Gatwick Airport Northern Runway Project

Appendix 7.3.2: Summary of Stakeholder PEIR and Updated PEI Responses –
Historic Environment

Application Document Ref: 5.3

PINS Reference Number: TR020005

DRAWING TITLE  
**Existing and Proposed Zones of Theoretical Visibility (ZTV) within 5km Radius Study Area**

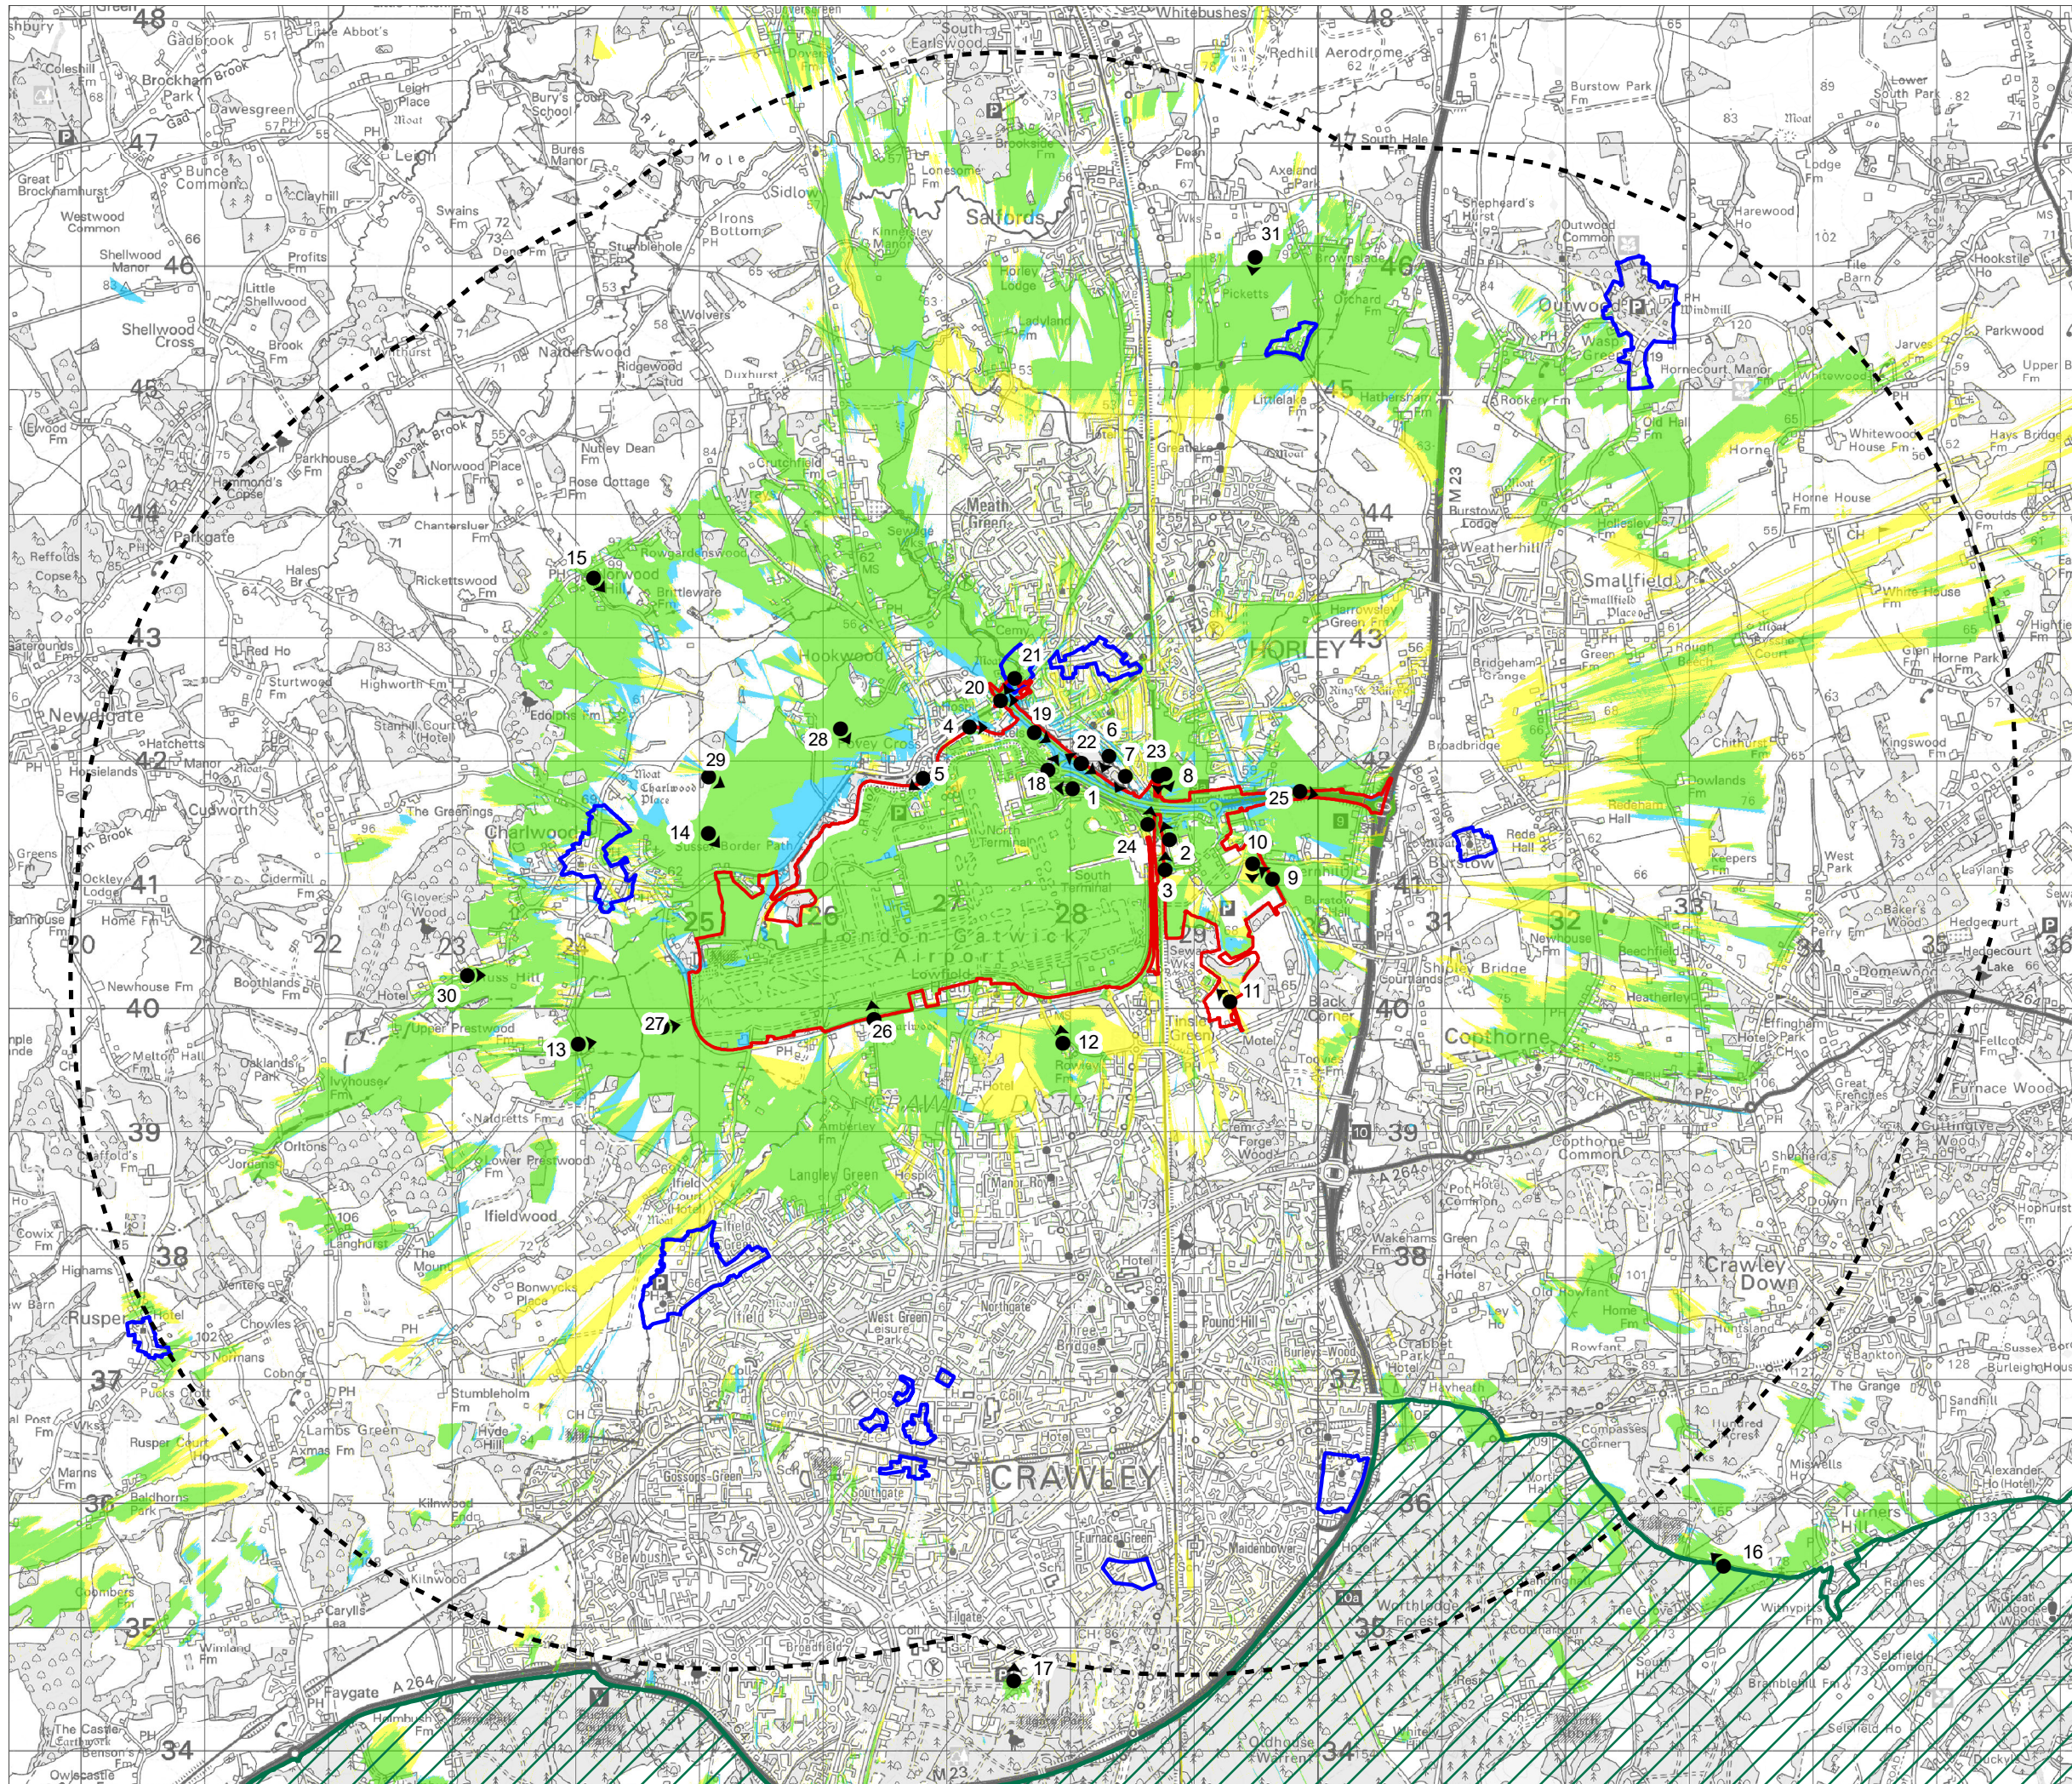
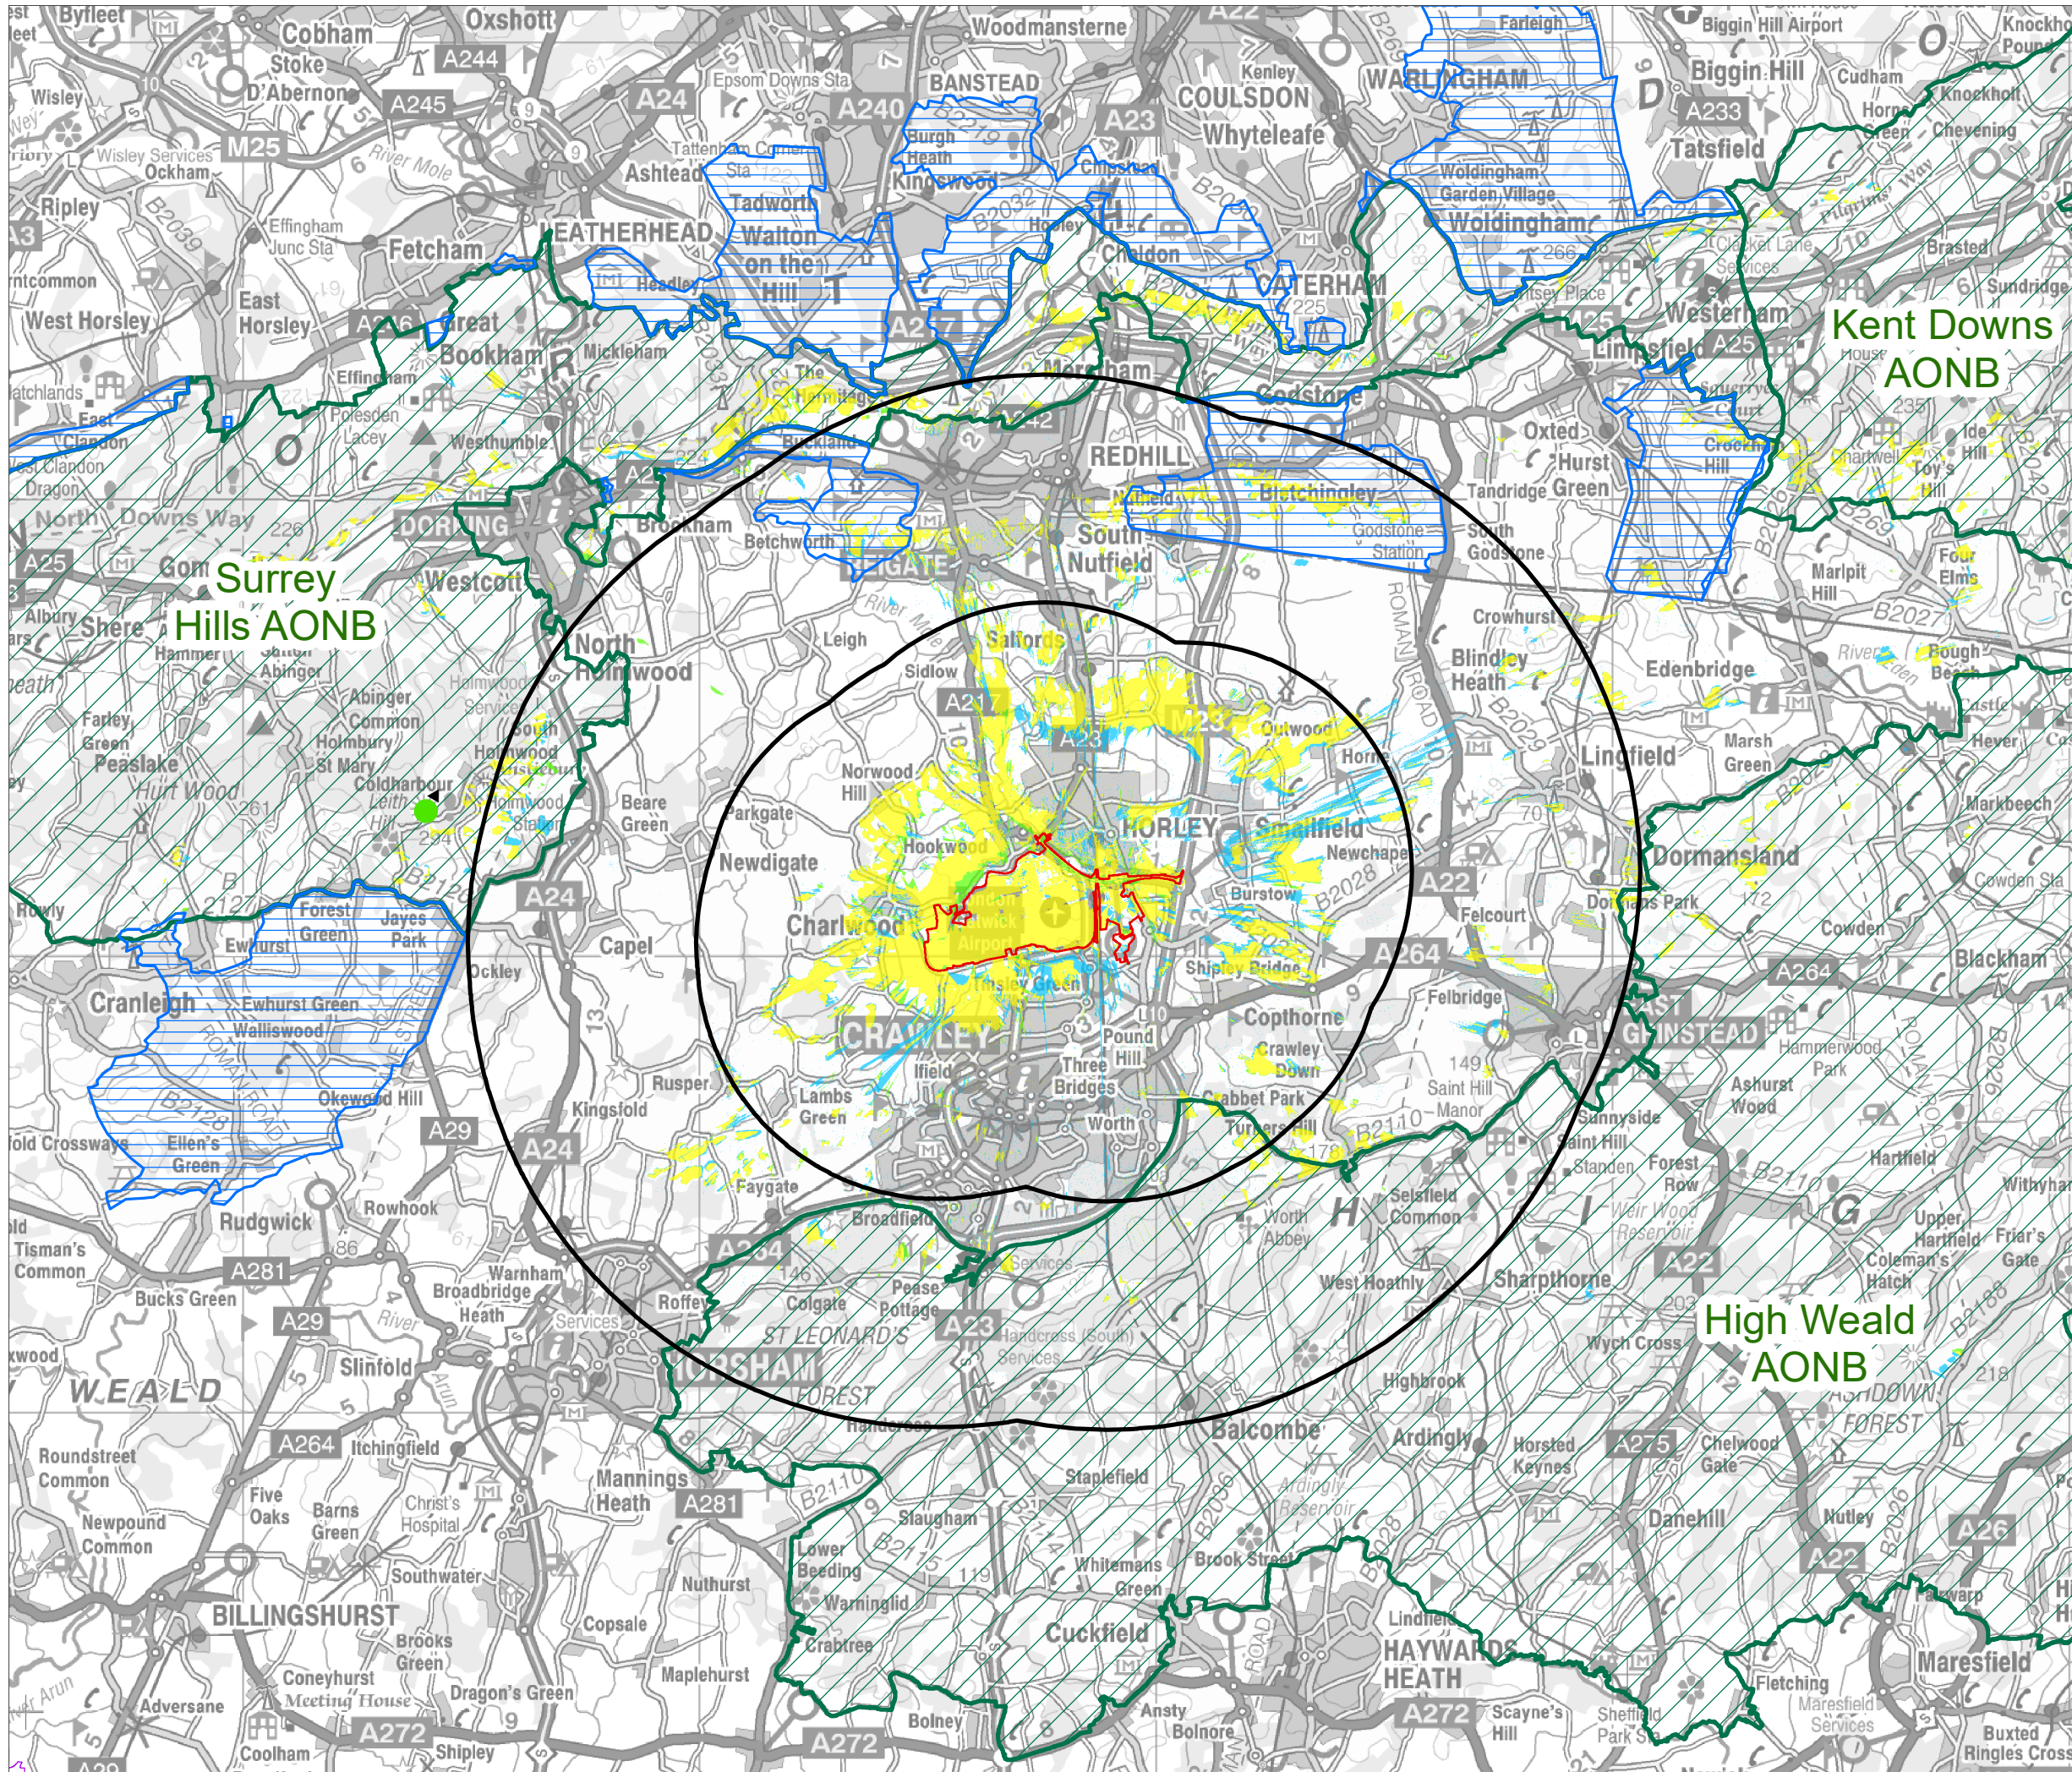
Surrey County Council	01 December 2021	[PEIR inaccuracies or deficiencies] The PEIR provides what appears to be a good catalogue of what is likely to be in the ZTV, but without visualisations, it is difficult to assess. Again we note suggestions from PINs that these be included.	The assessment of impacts and effects presented within Section 7.9 of ES Chapter 7: Historic Environment (Doc Ref. 5.1) includes references to visualisations when this is appropriate and helpful.
Surrey County Council	01 December 2021	[PEIR inaccuracies or deficiencies] Paragraph 7.9.111 indicates that no future monitoring is proposed with regard to the historic environment. Please note our comment on palaeochannels and potential waterlogged sites. Future monitoring may be necessary	No monitoring is proposed with regard to palaeochannels. Depending on the nature of the works proposed for the Project at any specific location it may be necessary to remove all waterlogged material from a palaeochannel (in order to prevent future
